Subject: FW: SSD 6617 Exhibition of application for remediation works, part Hickson Road, Barangaroo
Attachments: placarding-for storage-of-hazardous-chemicals-4630[1].pdf

From: Battye, Andrew [mailto:Andrew.Battye@safework.nsw.gov.au]
Sent: Friday, 20 November 2015 12:17 PM
To: Michele Nettlefold
Cc: Nikolovski, Steven; Finlay, Mary Ann; Sukara, Zoran; Robinson, Peter
Subject: SSD 6617 Exhibition of application for remediation works, part Hickson Road, Barangaroo

Therefore, please find following comments that relate specifically to the **storage and handling of the hazardous chemicals** that will be brought on site in the event of in-situ remediation work taking place.

STATUS: DRAFT
 DRAWING NO: 60247139-DRG-20-FSWP-F4
 REV: 02

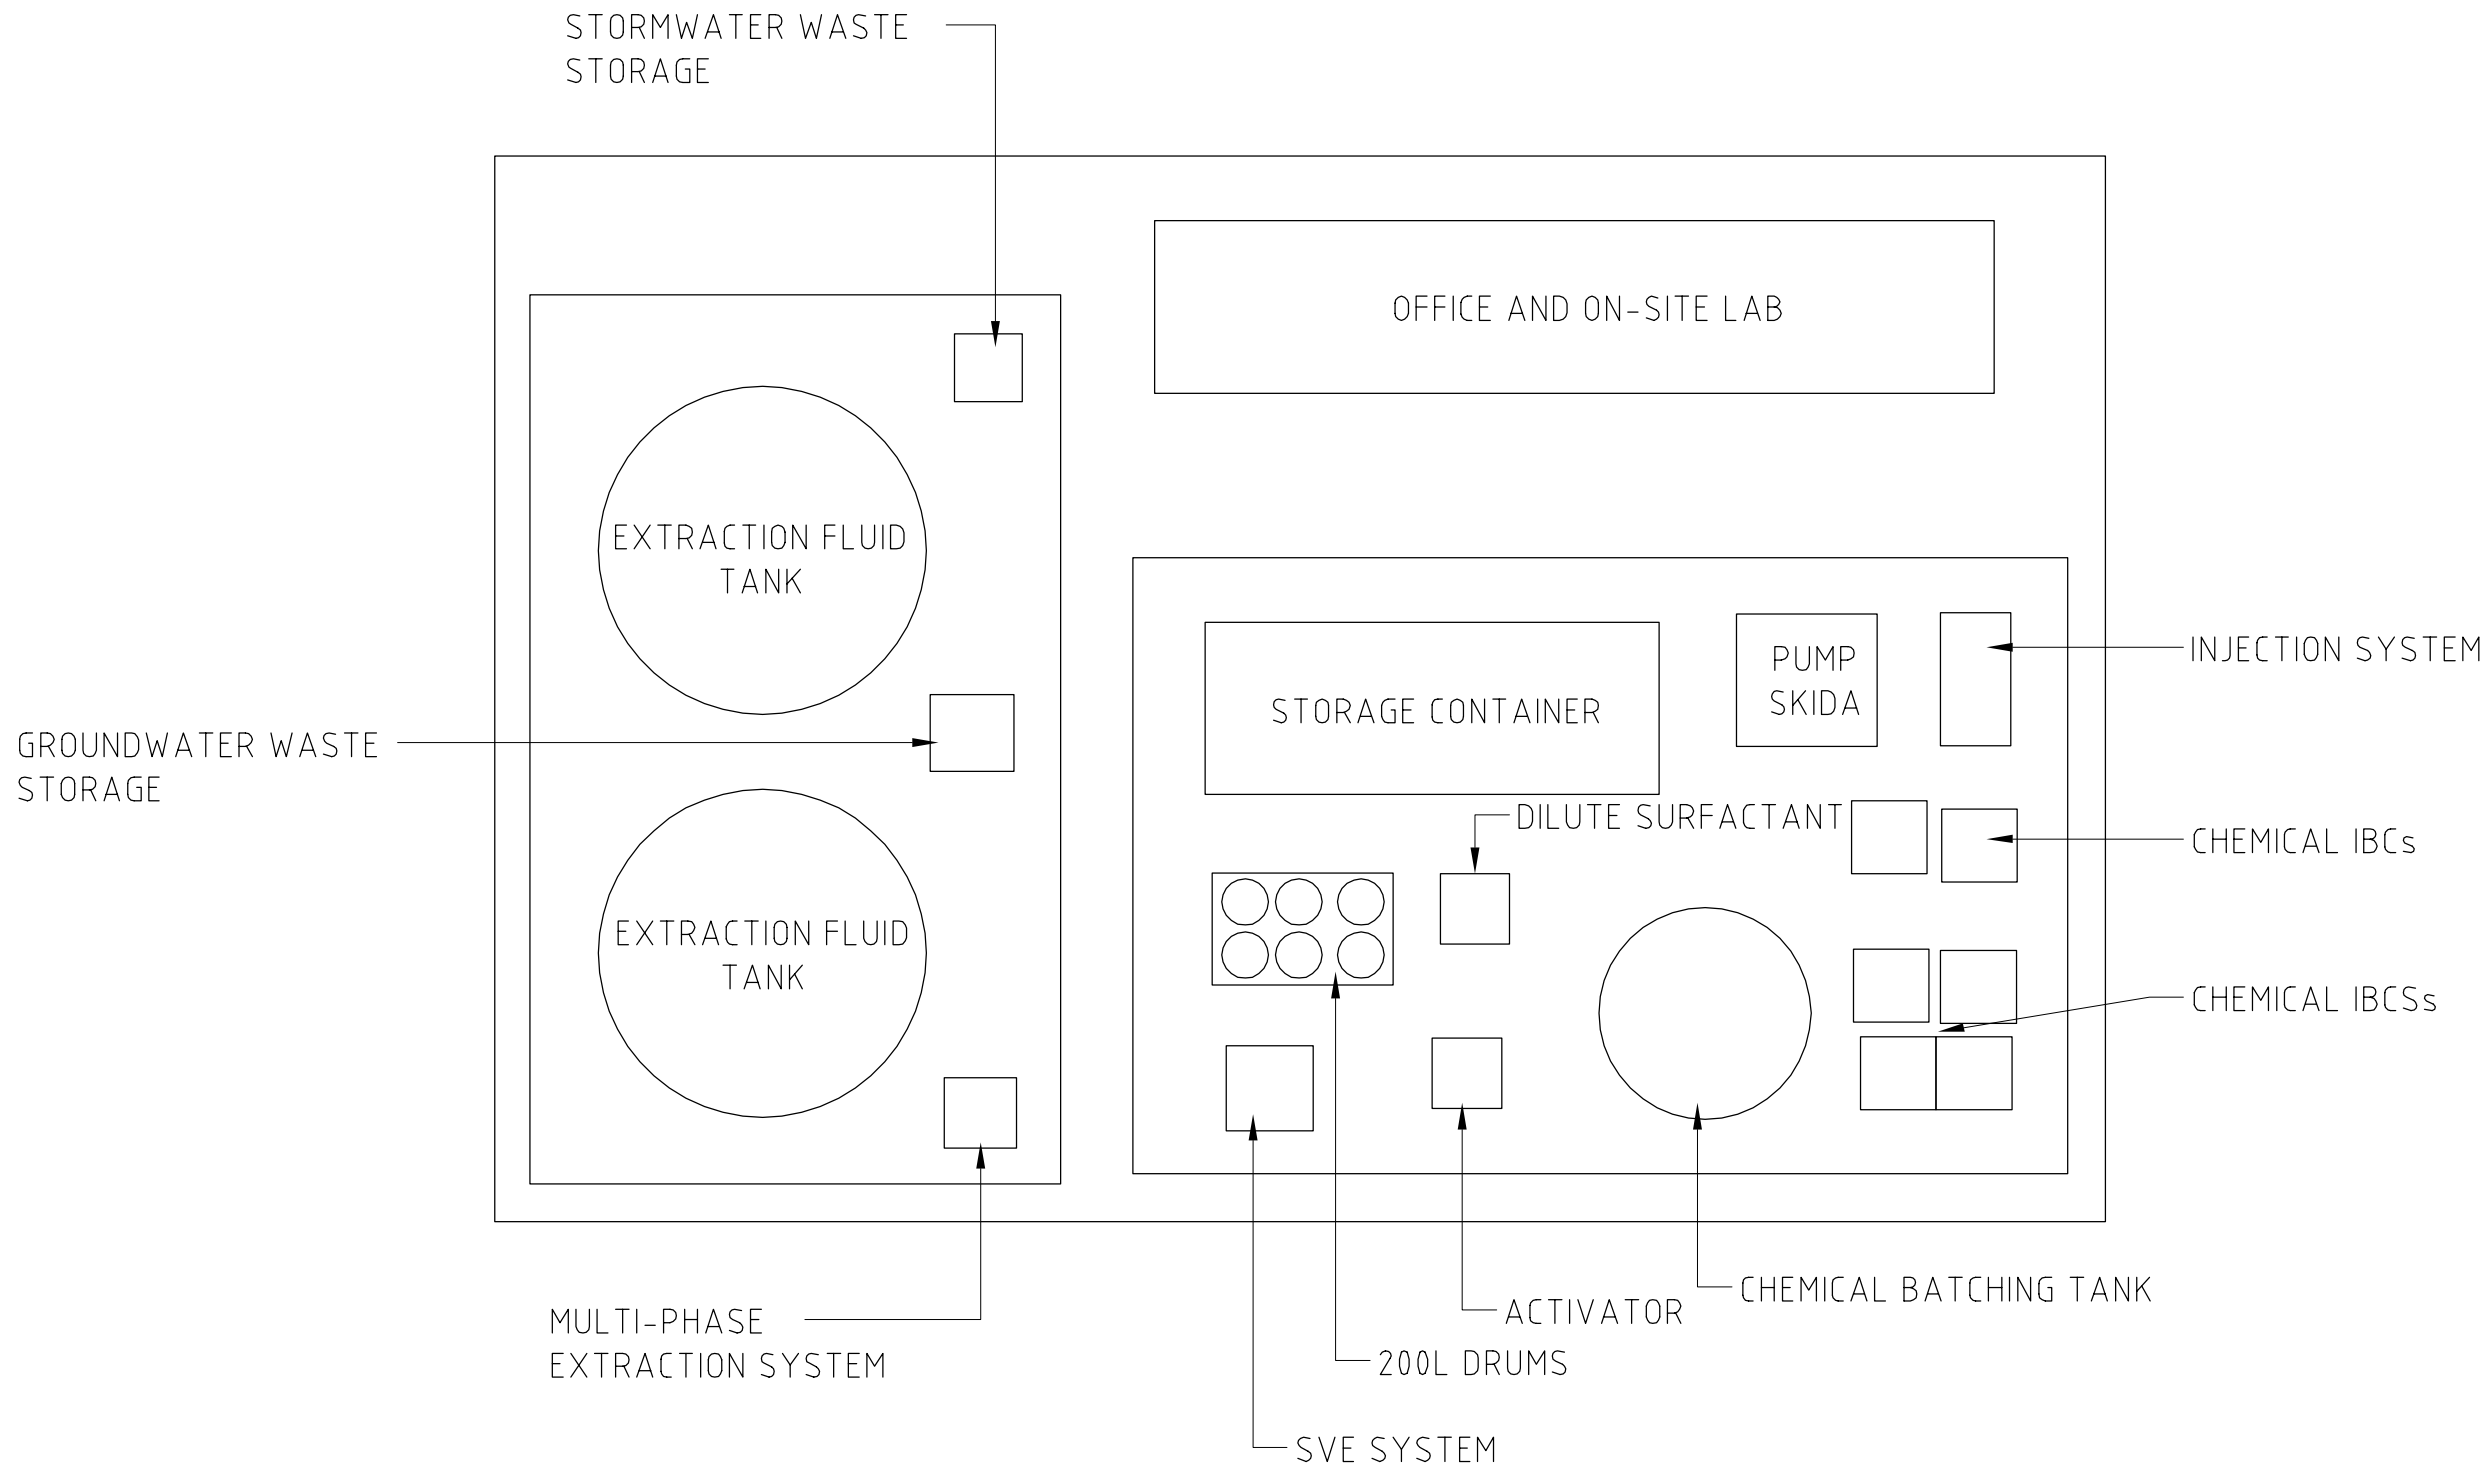
- h. **Hazardous areas**- (Surfactant) A hazardous area diagram needs to be developed to clearly show all hazardous areas (stage and transfer). Consideration of the prevention of ignition sources from on and off site need to be considered and procedures implemented. It is not sufficient to consider only the introduction of ignition sources from cigarette butts from the rock wall.

- j. **Protection from damage**- all storage of hazardous chemicals need to be protected from damage such as vehicular impact. It is recommended a traffic management plan be developed and consideration given to impact protection in particular for bulk storage.
